RESPONSE TO SUBMISSIONS: WENTWORTHVILLE NORTHSIDE WEST CLINIC EXTENSION

23-27 LYTTON STREET, WENTWORTHVILLE
LOT 1 DP787784

RESPONSE TO SUBMISSIONS REPORT

SSD-17899480

5 Shadow Diagram\_Winter Solstice 1200  
 Scale: 1 : 1000

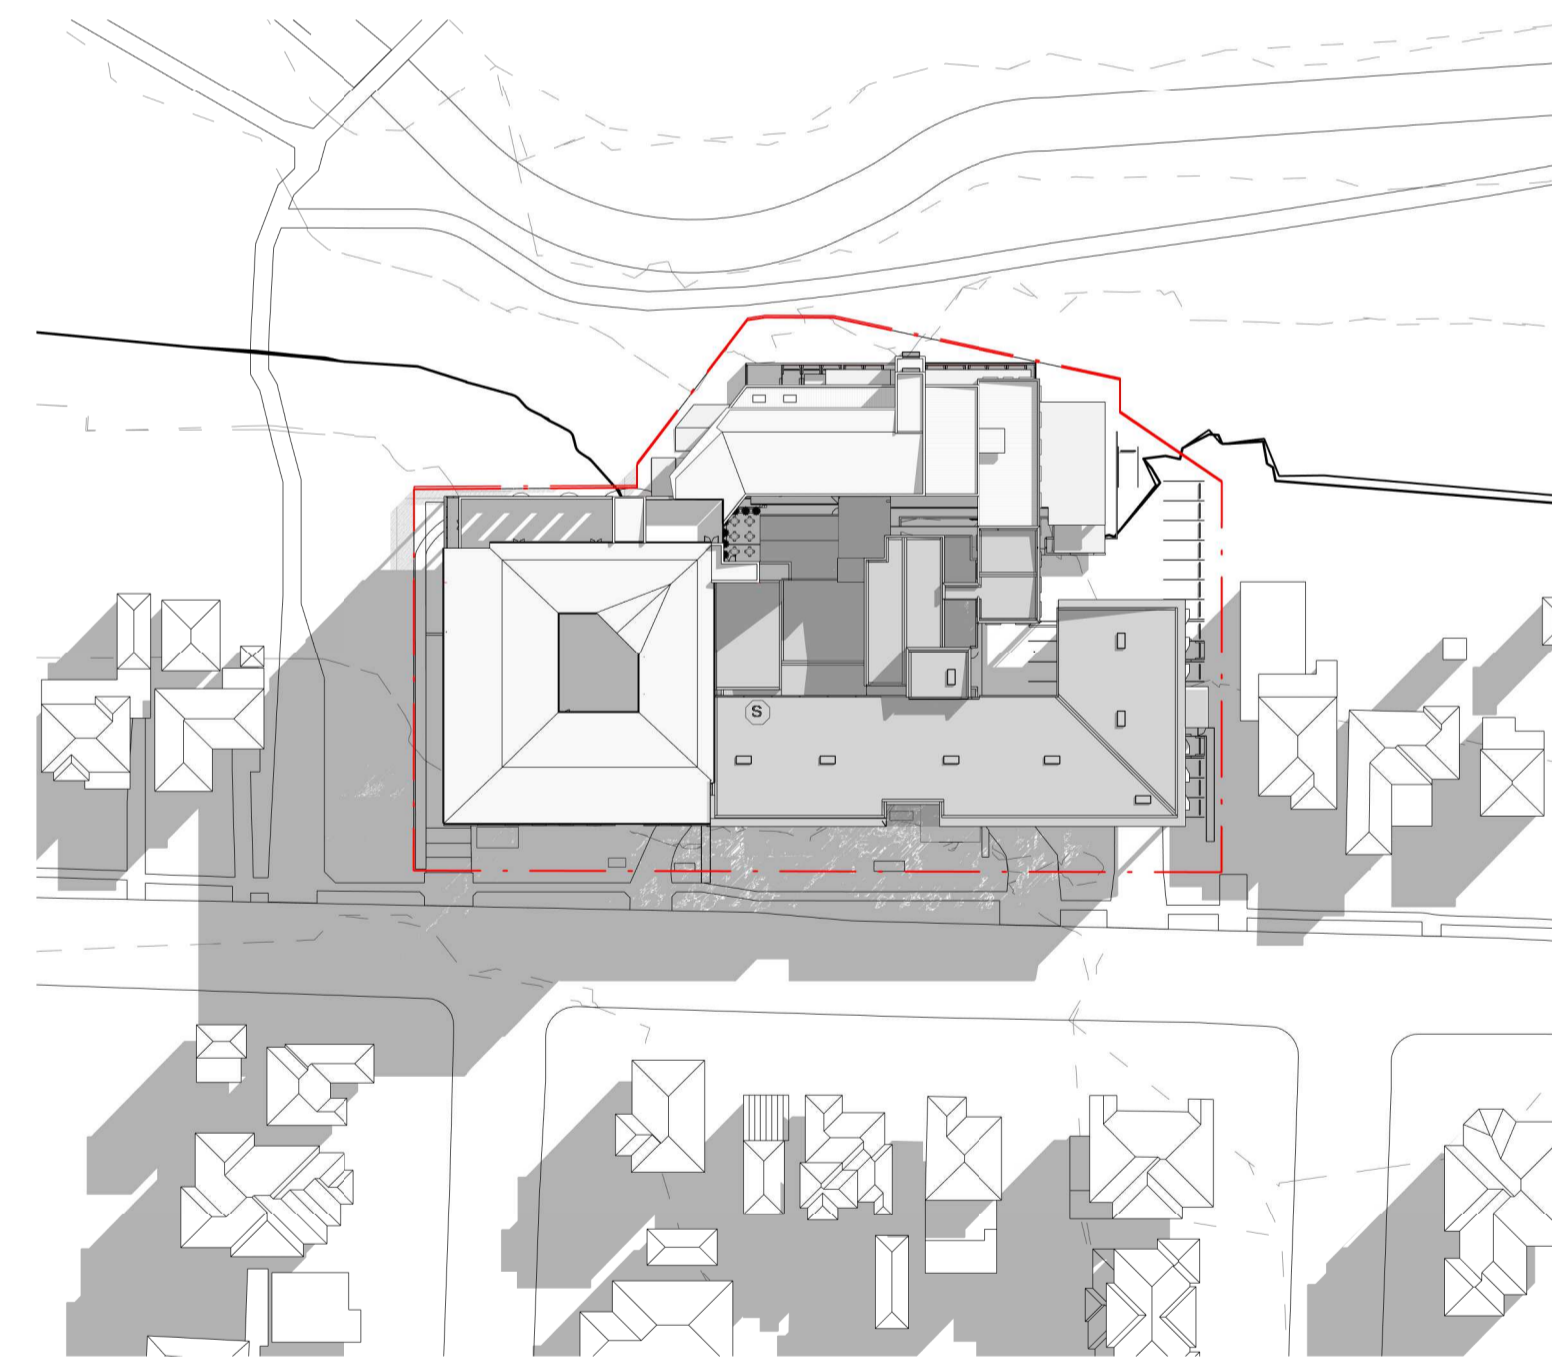
<ul style="list-style-type: none"> ○ demonstrate the overshadowing which would be created by the hanging planters, ensuring adequate solar access is experienced within this space and to internal rooms. 	<p>As illustrated in the Shadow Diagrams within the Architectural Plans, the courtyard and patient rooms will receive adequate solar access during summer solstice. It is noted that the patient rooms on Level 1 and 2 will continue to receive acceptable level of sunlight access on winter solstice. While the courtyard will be</p>

**1 SECTION A-A SHADOW-WINTER SOLSTICE**  
Scale: 1 : 100

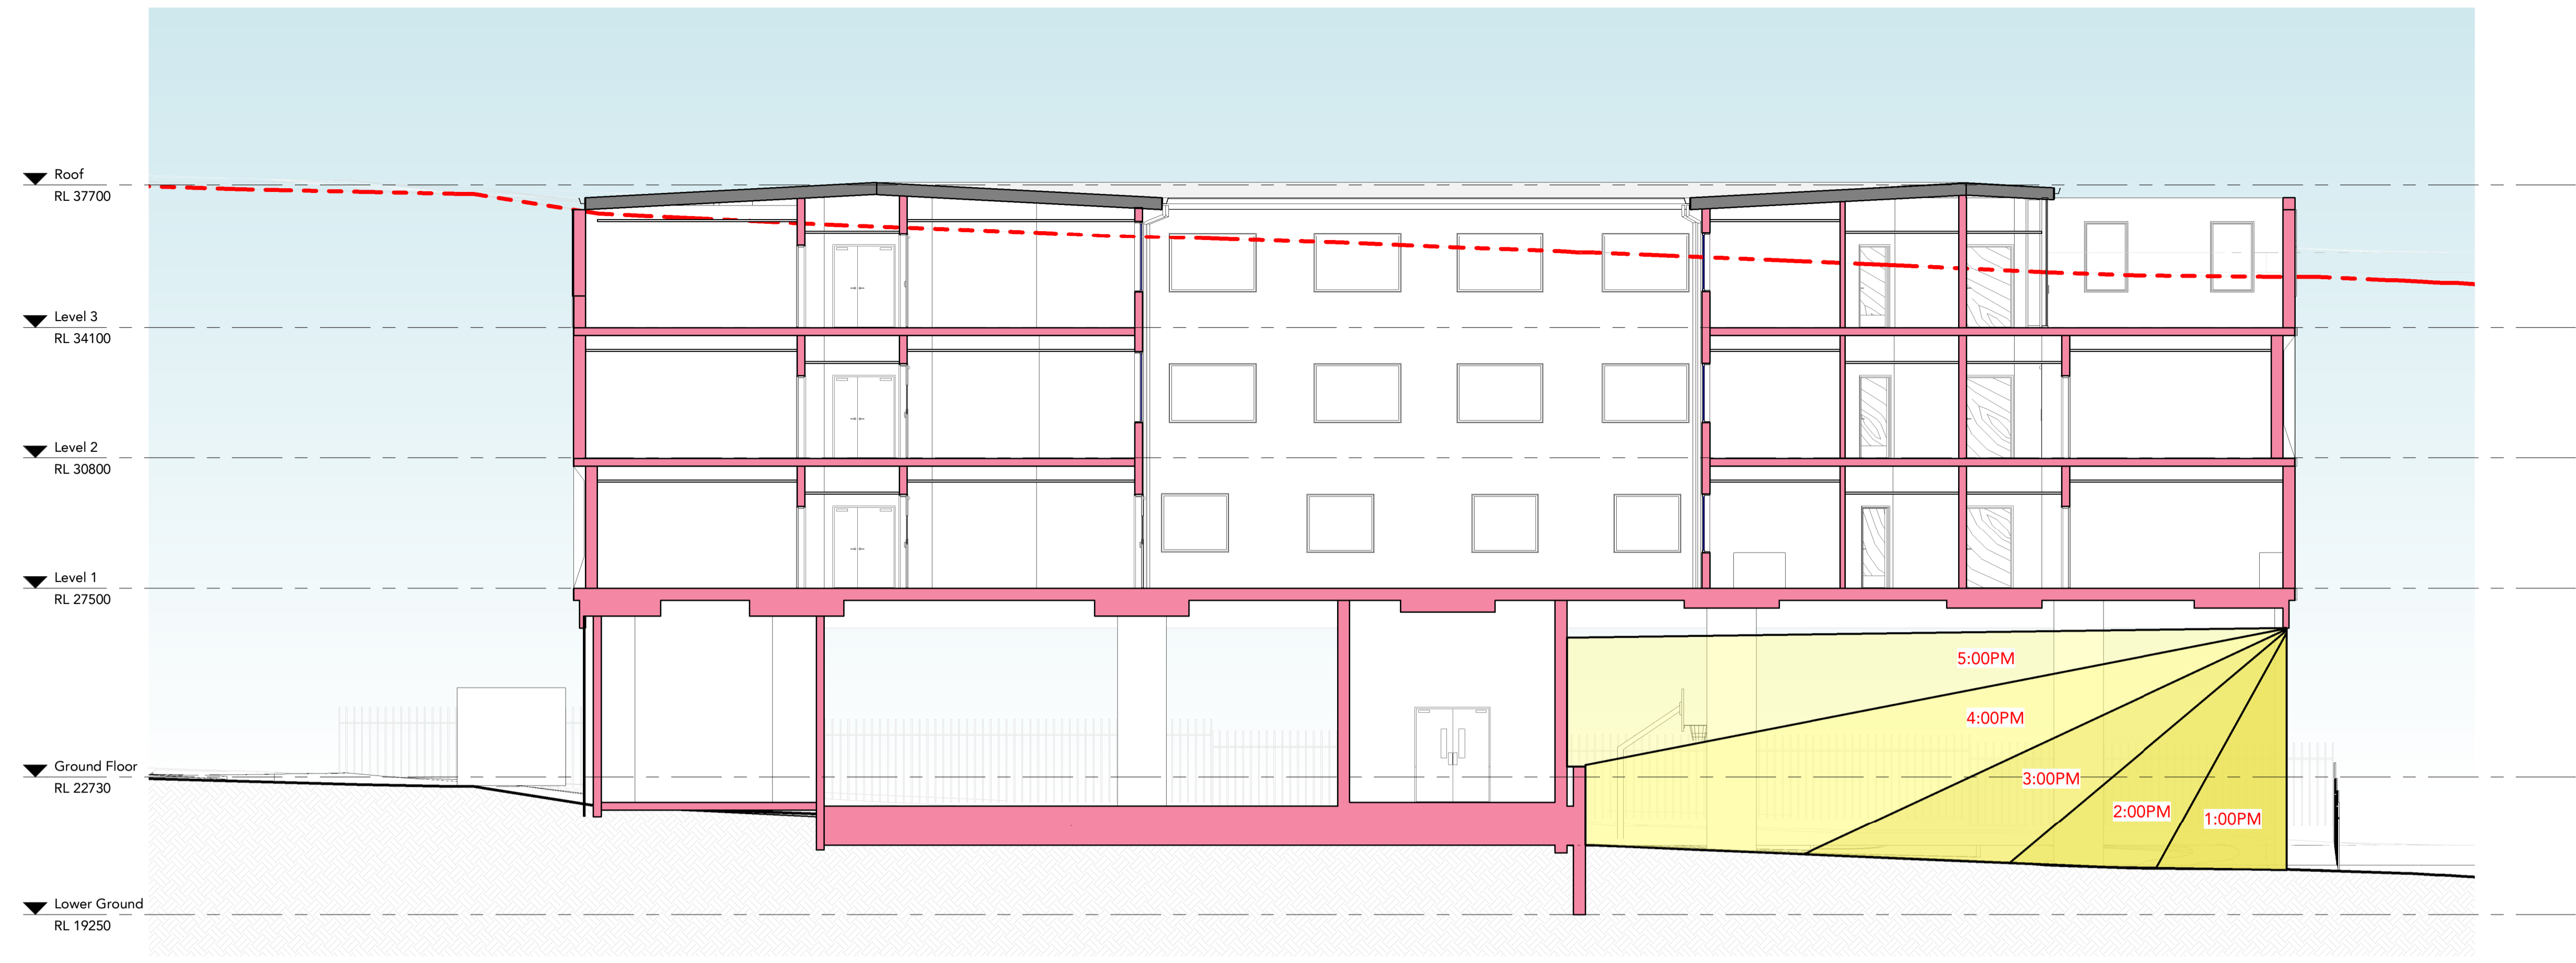
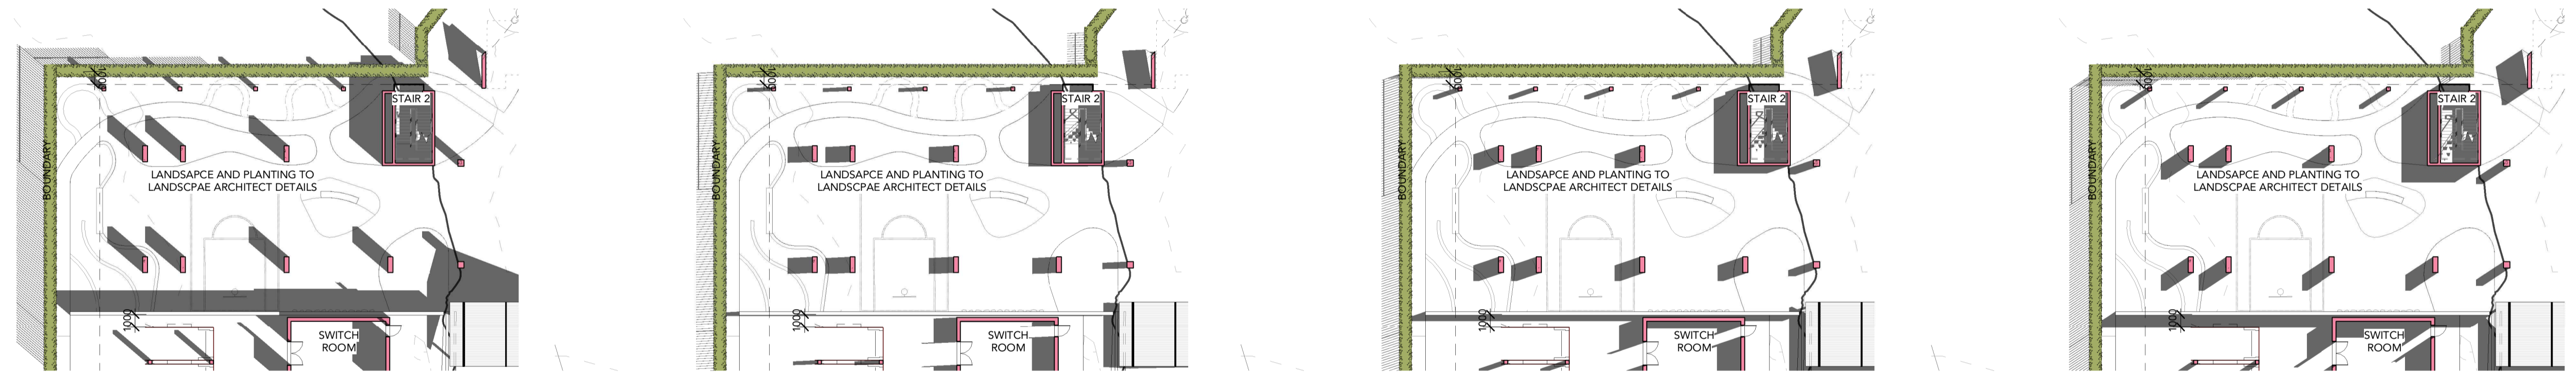
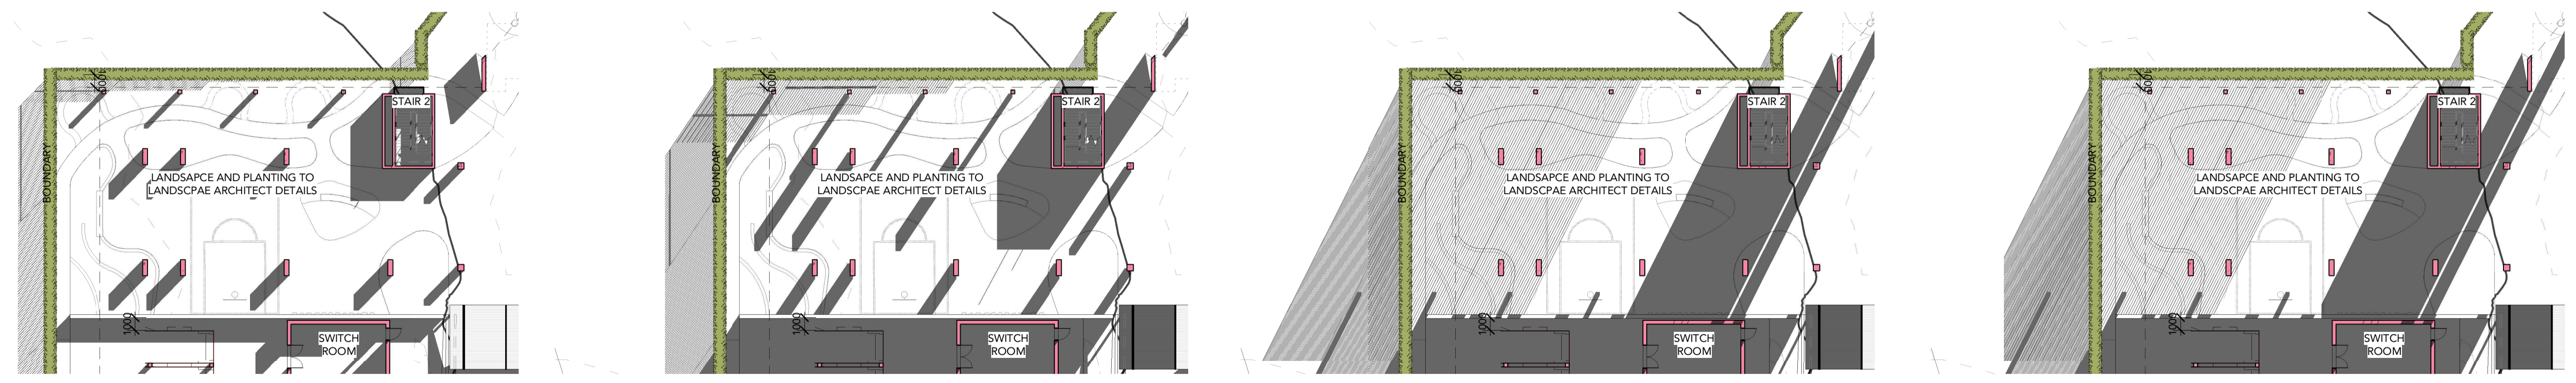
Demonstrate how the undercroft landscaped area will receive adequate solar access as well as appropriate passive surveillance considering there are limited active use rooms with windows on the ground floor facing this part of the development.	<p>As demonstrated in the Courtyard Shadow Diagrams within the Architectural Plans, the courtyard will receive adequate sunlight between 9am and 3pm on winter solstice. There will only be minor overshadowing from the building columns and the staircase, which is not considered to adversely impact on the sunlight access of the courtyard.</p> <p>In relation to passive surveillance, it is noted that the proposed courtyard will be located on ground level fronting Lytton Street Park to the west, facilitating the visual connection with the</p>
